From: Giles Dixon [REDACTED]
Sent: 10 October 2017 15:30
To: Anita Gardner
Subject: Re: AB/82/16/PL Change of Use to create 2 dwellings

Drawing title:
Plot 3-4 Sketch Section

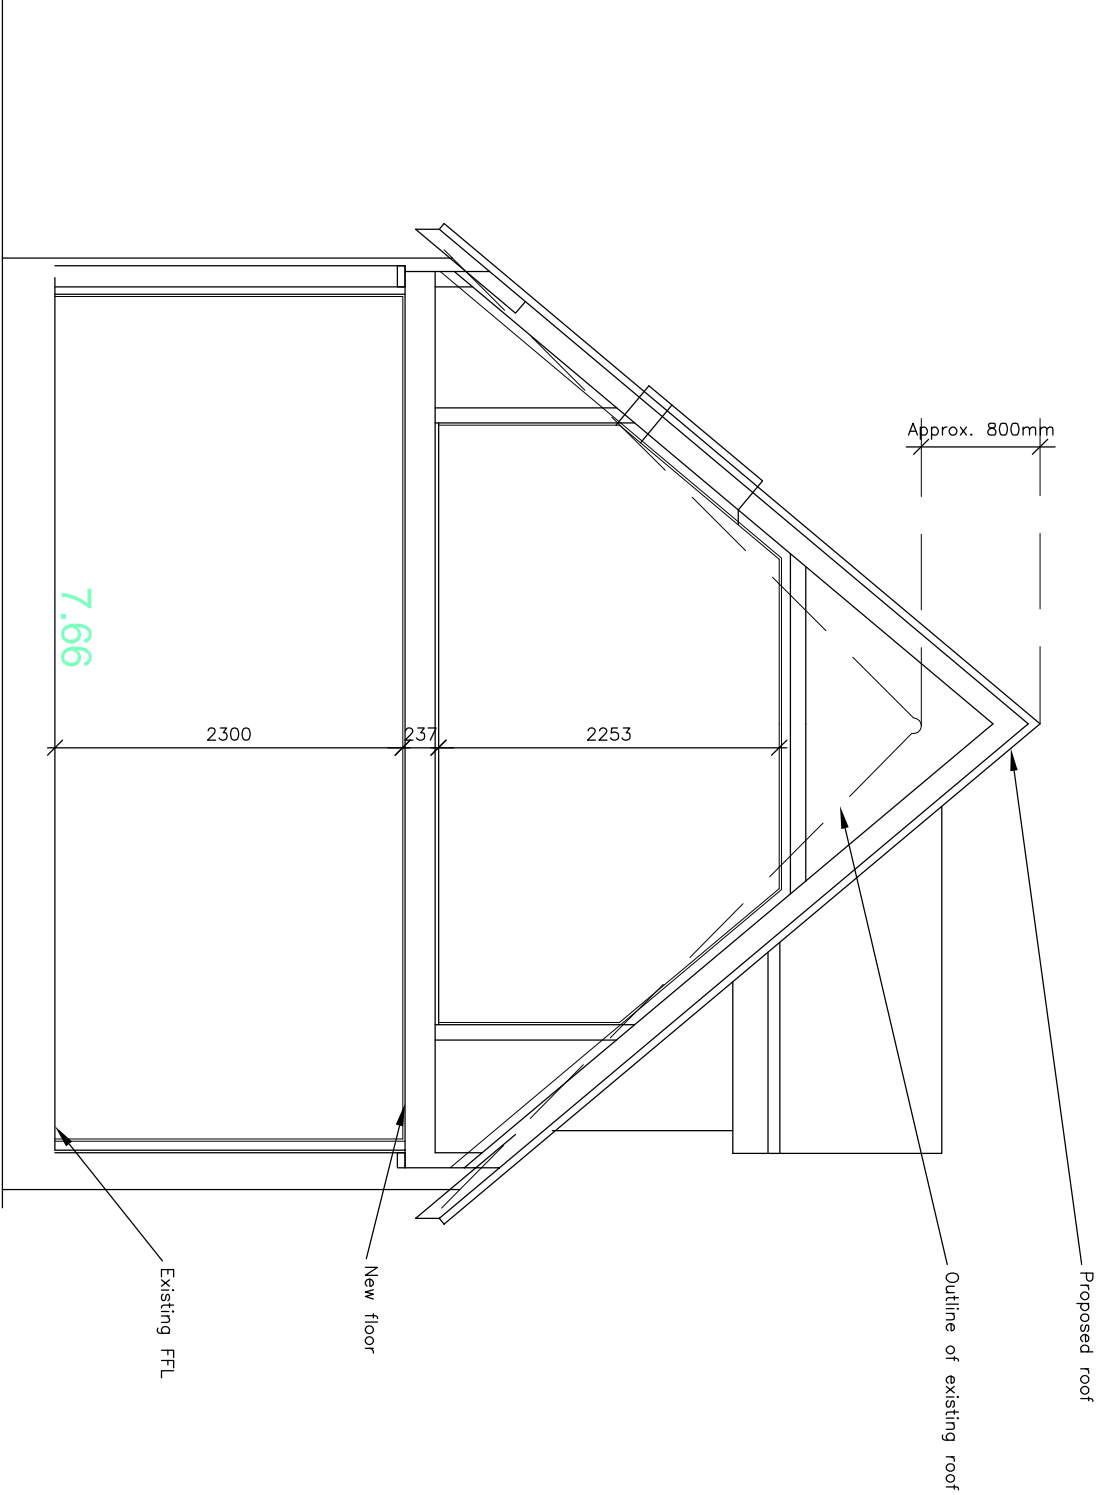
I refer to the above application. I note that reroofing and dormers are proposed and I would appreciate receipt of either existing elevation plans or comparative cross sections to demonstrate if there is any increase in the height of the property proposed.

The short answer to your question is yes, there is an increase in height and I have asked the architect to produce the attached sketch to show this.
